From: Martin Hill <Martin.Hill@arun.gov.uk>
Sent: 22 March 2022 09:48
To: Planning.Responses <Planning.Responses@arun.gov.uk>
Subject: RE: Planning Consultation on: BR/42/22/PL

Comments from Private Sector Housing:

Application No: BR/42/22/PL
Registered: 3rd March 2022
Site Address: Prince Of Wales Public House 1 Highfield Road Bognor Regis PO22 8BQ

Description of Works: Change of use from public house (A4 Drinking establishment) to an 18-bed student accommodation. This application is in CIL Zone 4 (Zero Rated) as other development.

Drawing Title:
PROPOSED FLOOR PLANS, ELEVATIONS, SECTION

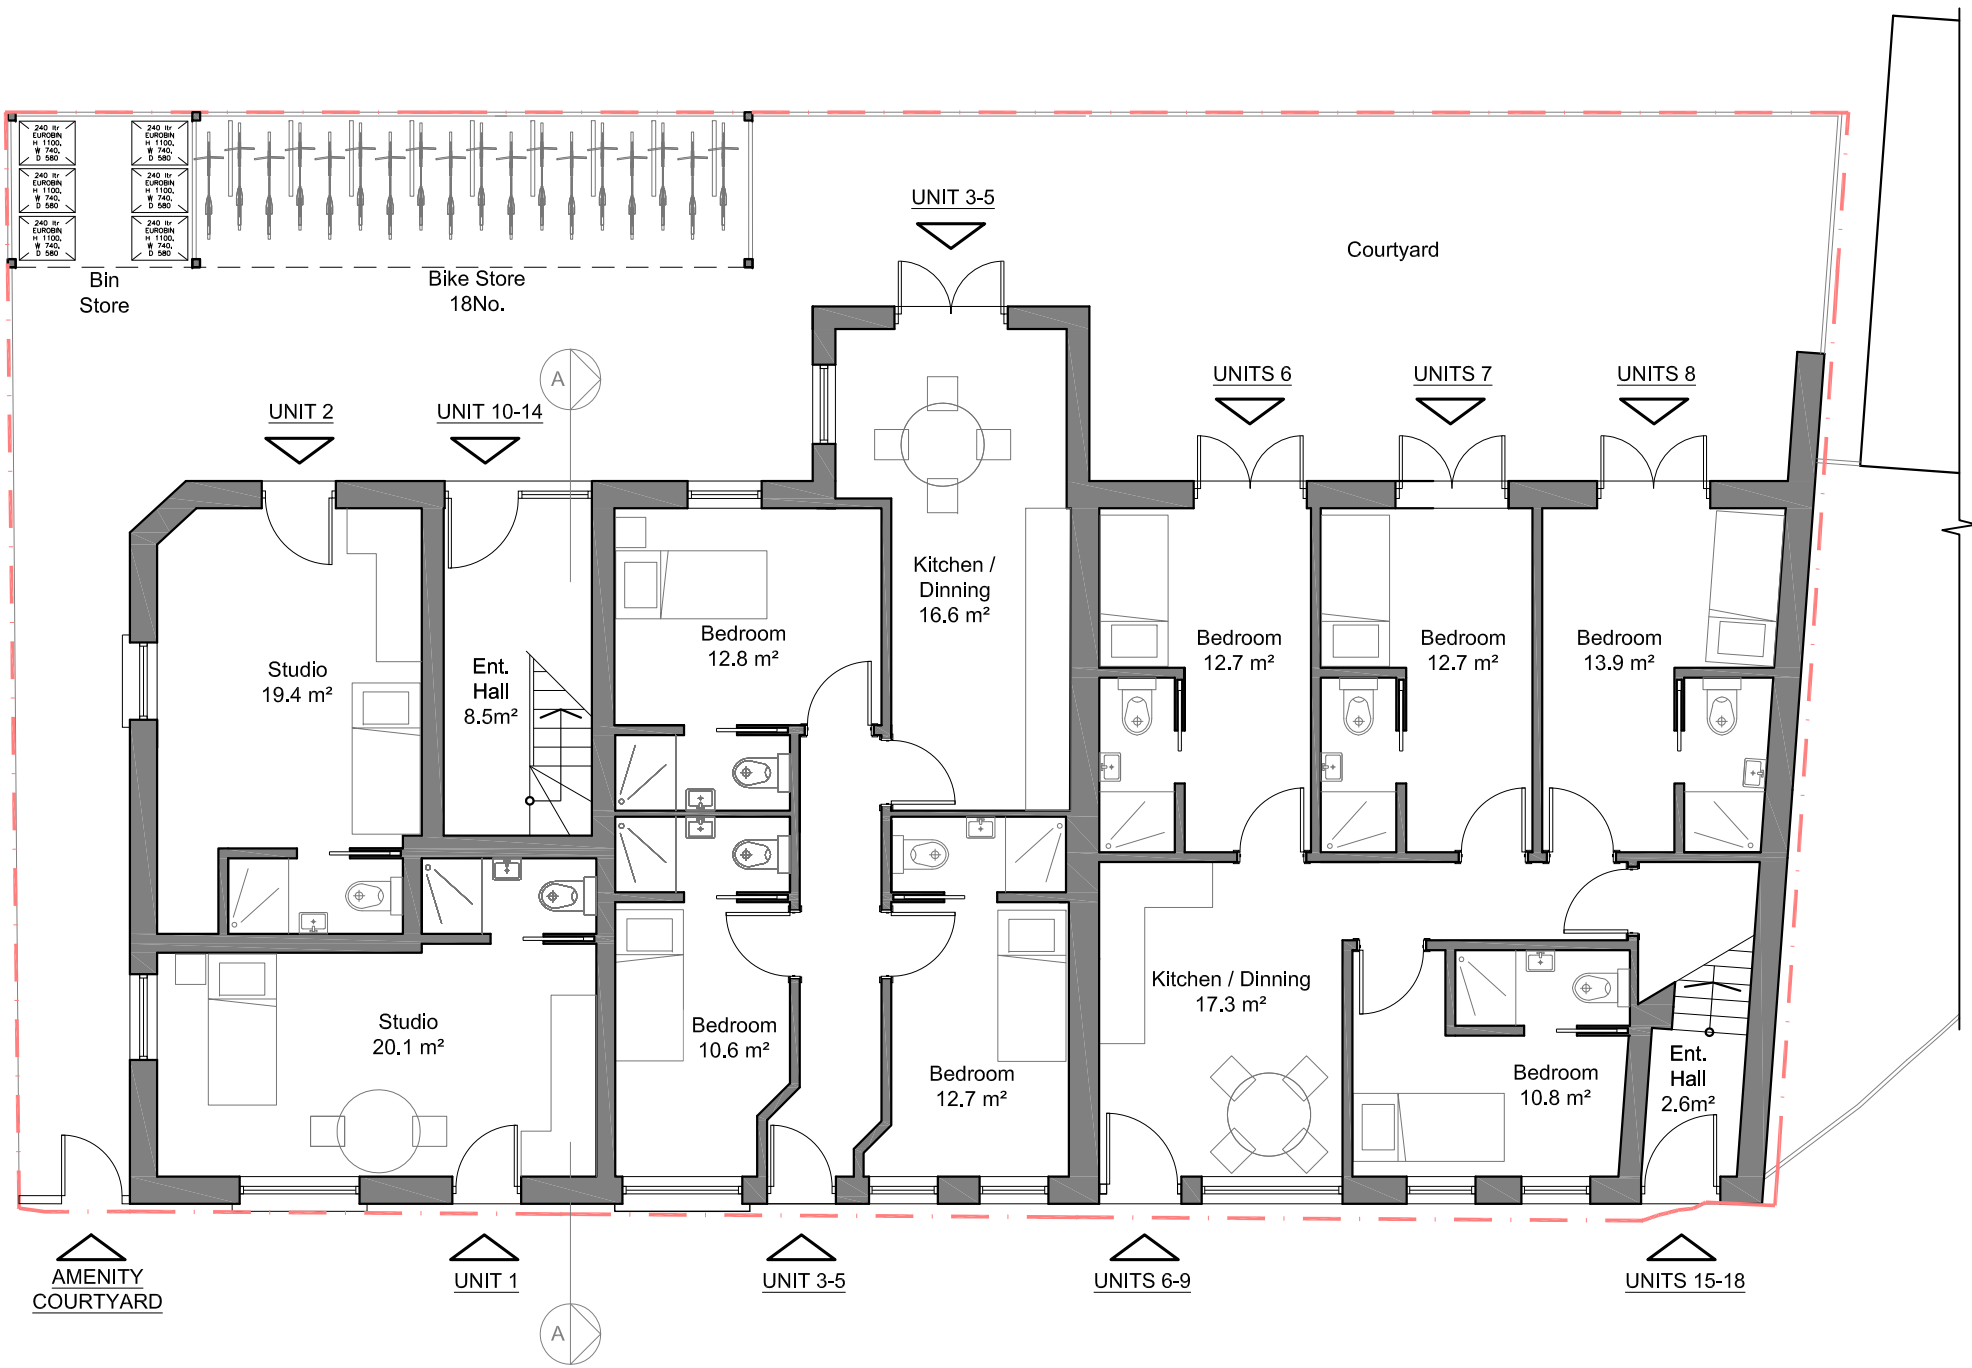
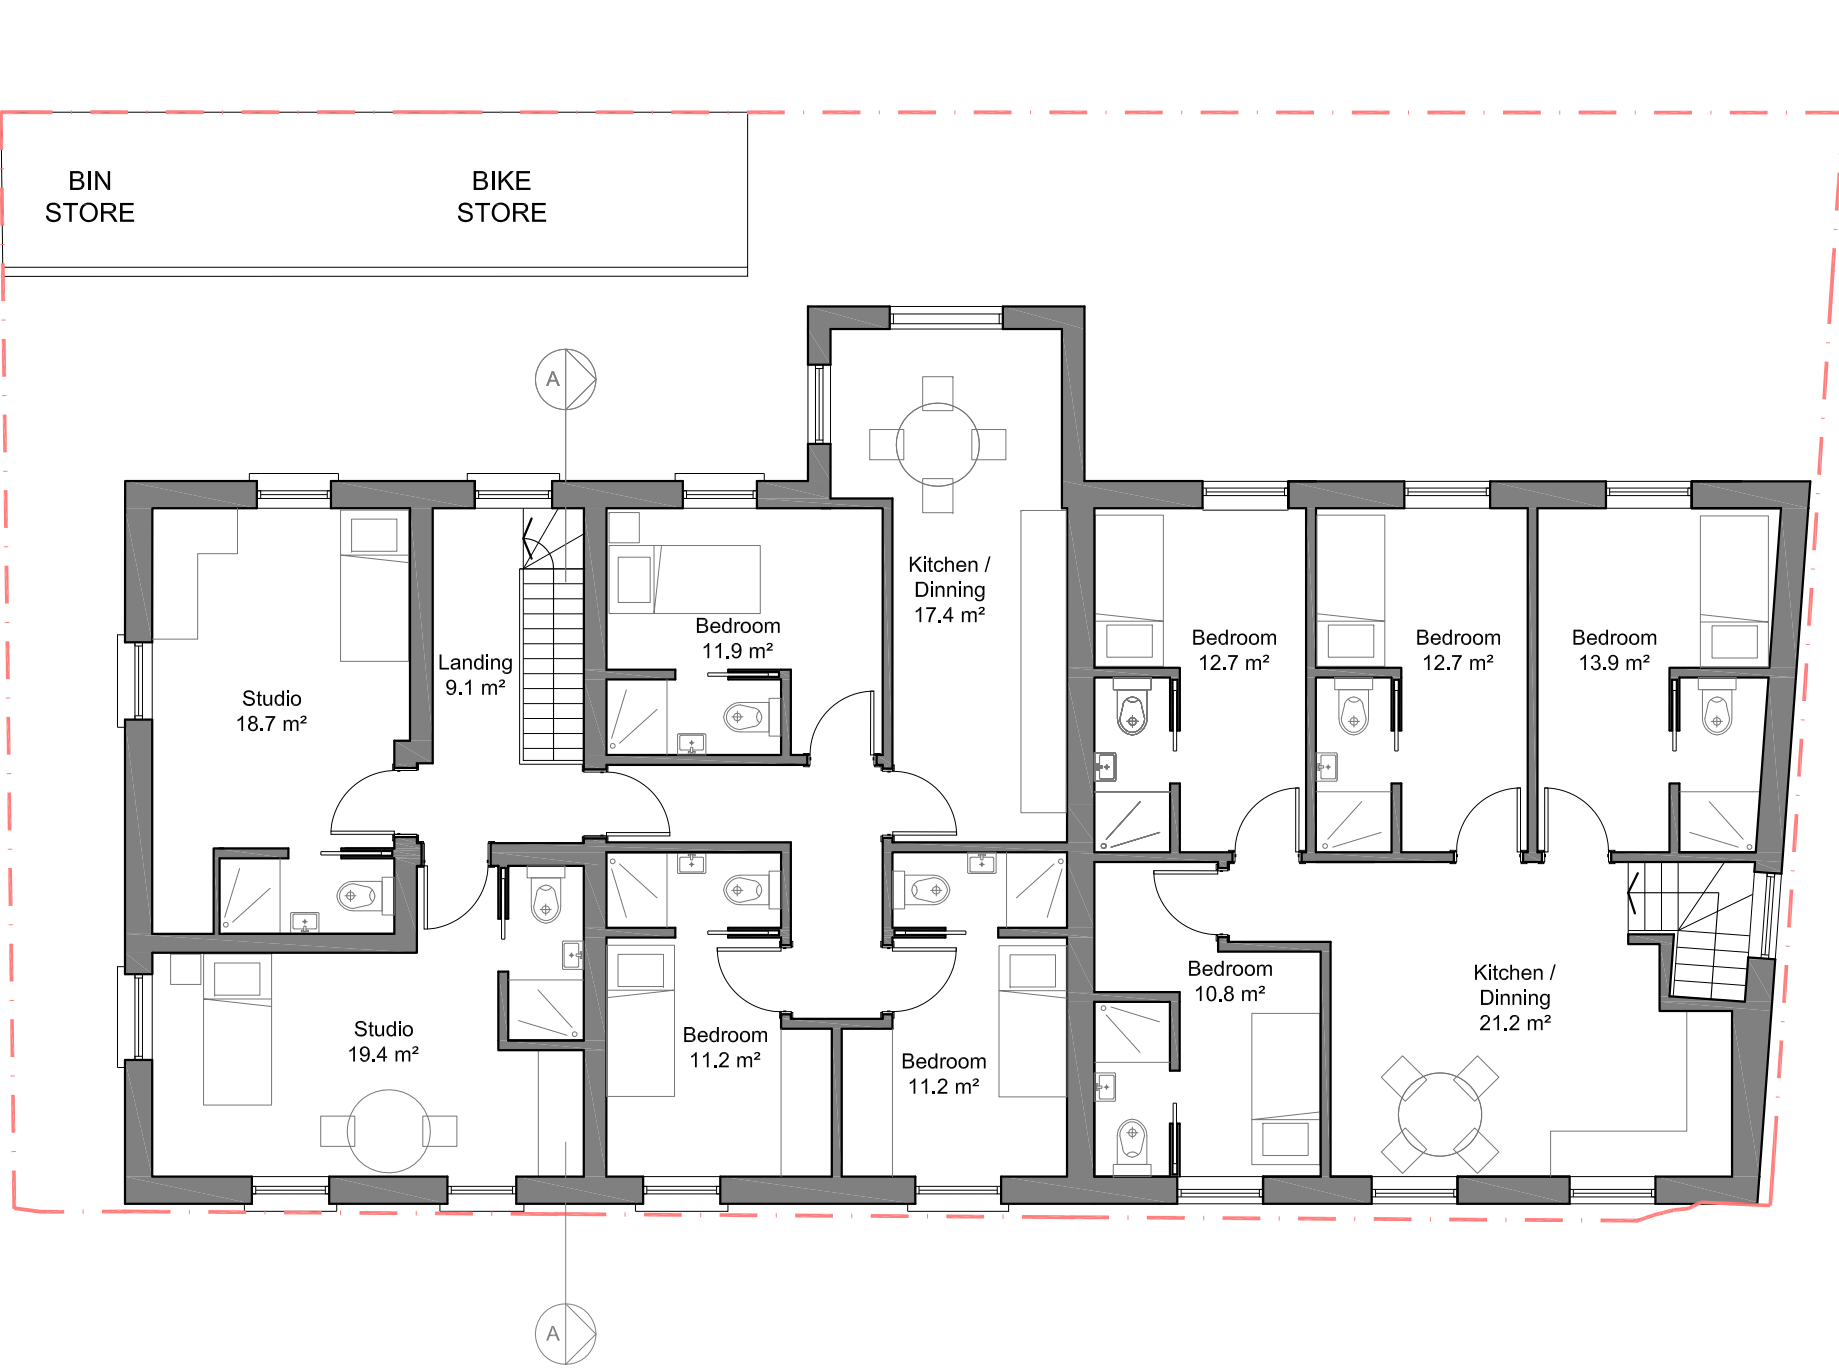
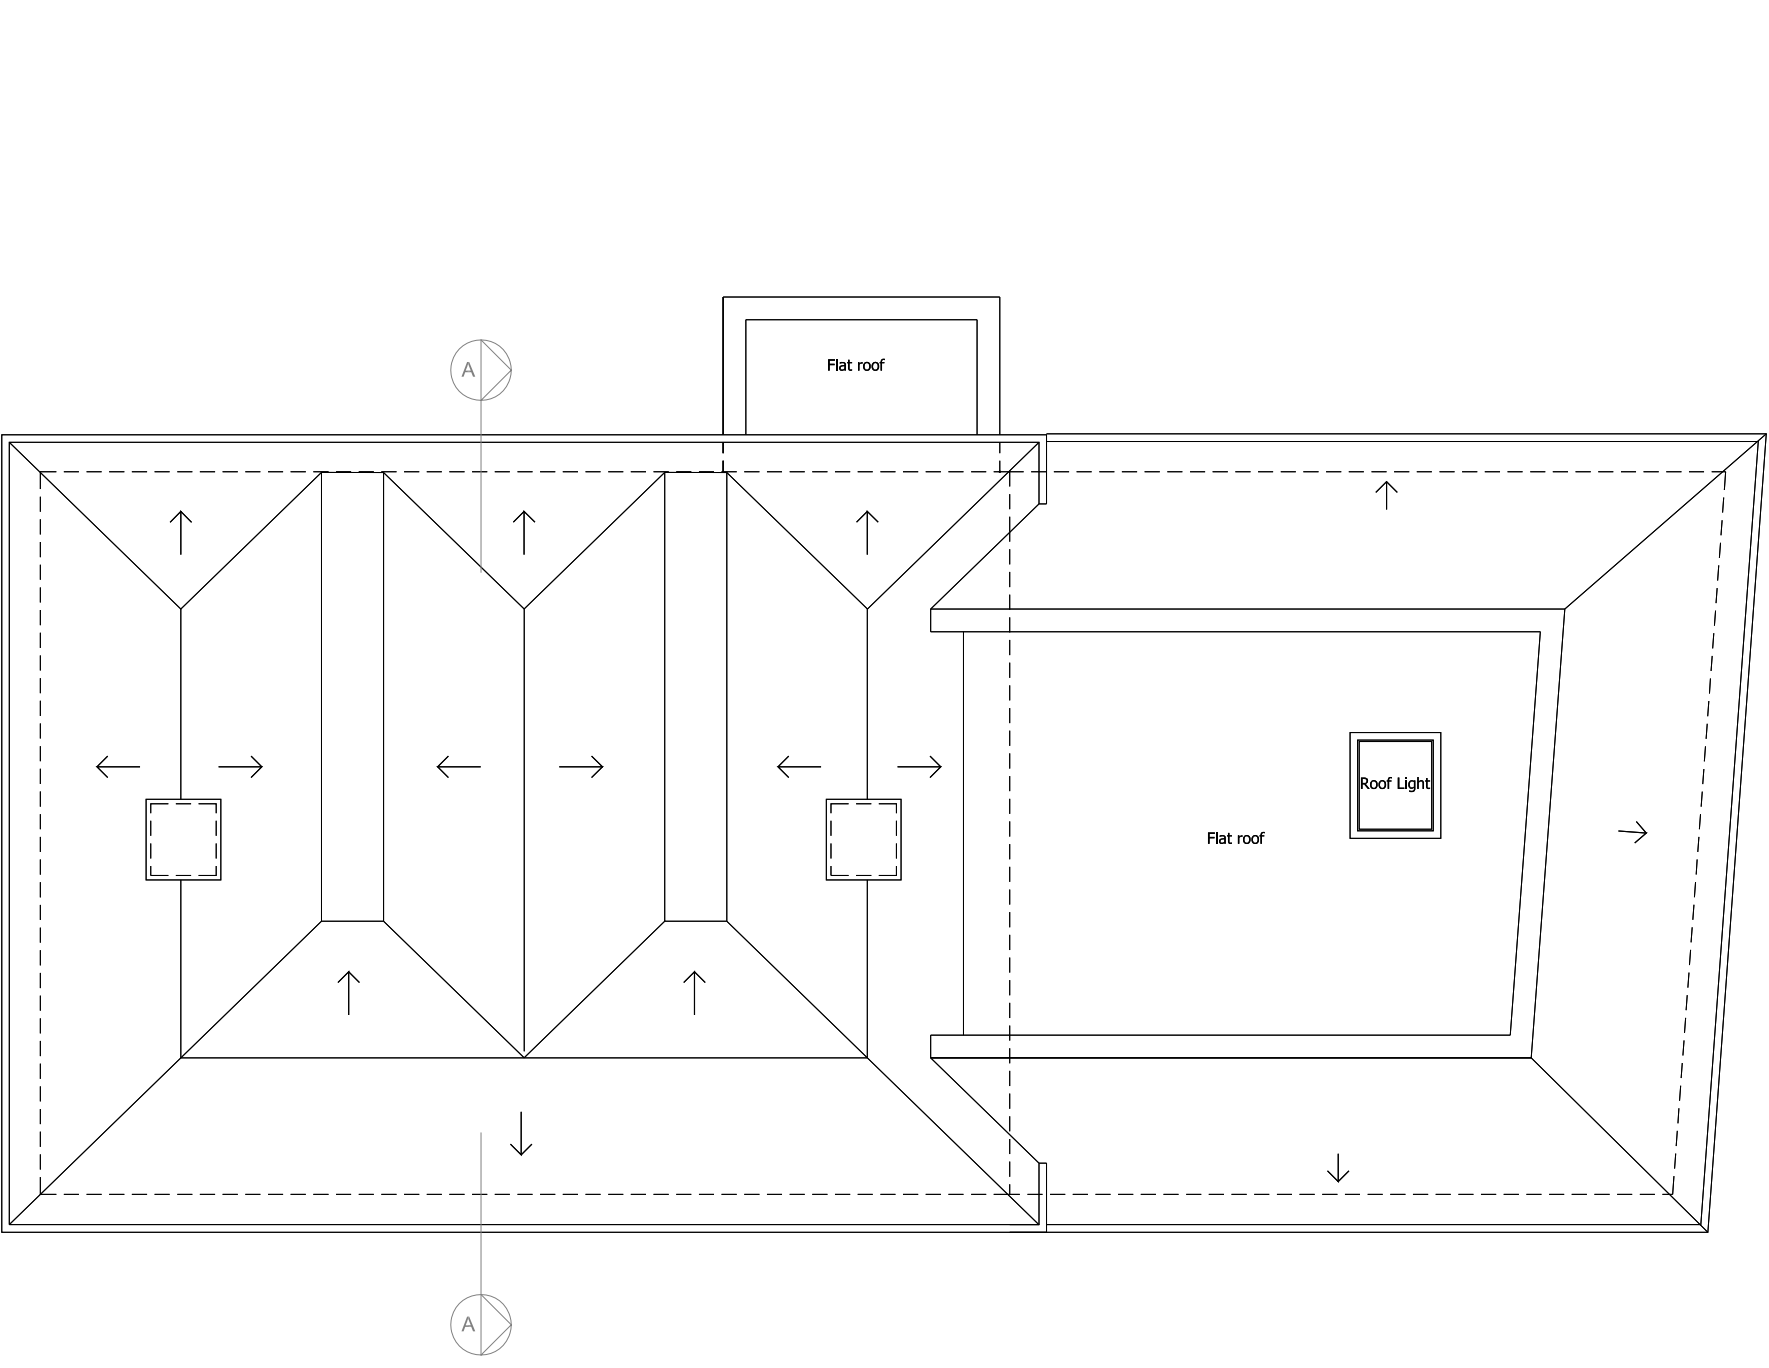
- A room where the only escape route is through another room is termed an “inner room” and poses a risk to its occupiers if a fire starts unnoticed in the outer room. The escape routes from the bedsits in Units 6, 7, 8 & 9 on both ground and first floors are via kitchen-diners. The ideal solution should be to separate each kitchen-diner with a 30 minute fire-resisting partition wall and FD30S fire door, with a hallway providing an access and egress route serving each bedsit and kitchen-diner. In accordance with LACoRS fire safety guidance, an alternative solution could be to provide an escape window in each bedsit which leads to a place of ultimate safety, plus interlinked smoke detection in both the kitchen-diner area and each bedsit and installing an FD30S fire door to each bedsit (between the inner and outer rooms). This can only be considered where the ground to first floor storey height is less than 4.5 metres and only where the inner room situation is unavoidable. In the opinion of Private Sector Housing, the inner rooms proposed are avoidable and therefore the kitchens

should be separated from other areas as detailed above and as demonstrated in the proposal for units 3 – 5 and 10-14, thus creating a suitable internal escape route.

- 30min fire resisting escape route serving each unit, which would include providing a 30 minute fire resisting and self-closing fire door to each risk room. Fire doors must be of FD30S standard, including 3 fire rated hinges, intumescent strips and cold smoke seals and an overhead self-closing device fitted. Bedsit, studio doors and final exit doors must also be fitted with thumb-turn style opening devices to enable a swift exit in the event of an emergency without the need for a key, code or card. The external exit gate from the courtyard must also be fitted with a thumb-turn, push pad, push bar or similar device to enable escape to ultimate safety from the courtyard area without the need for a key, code or card.
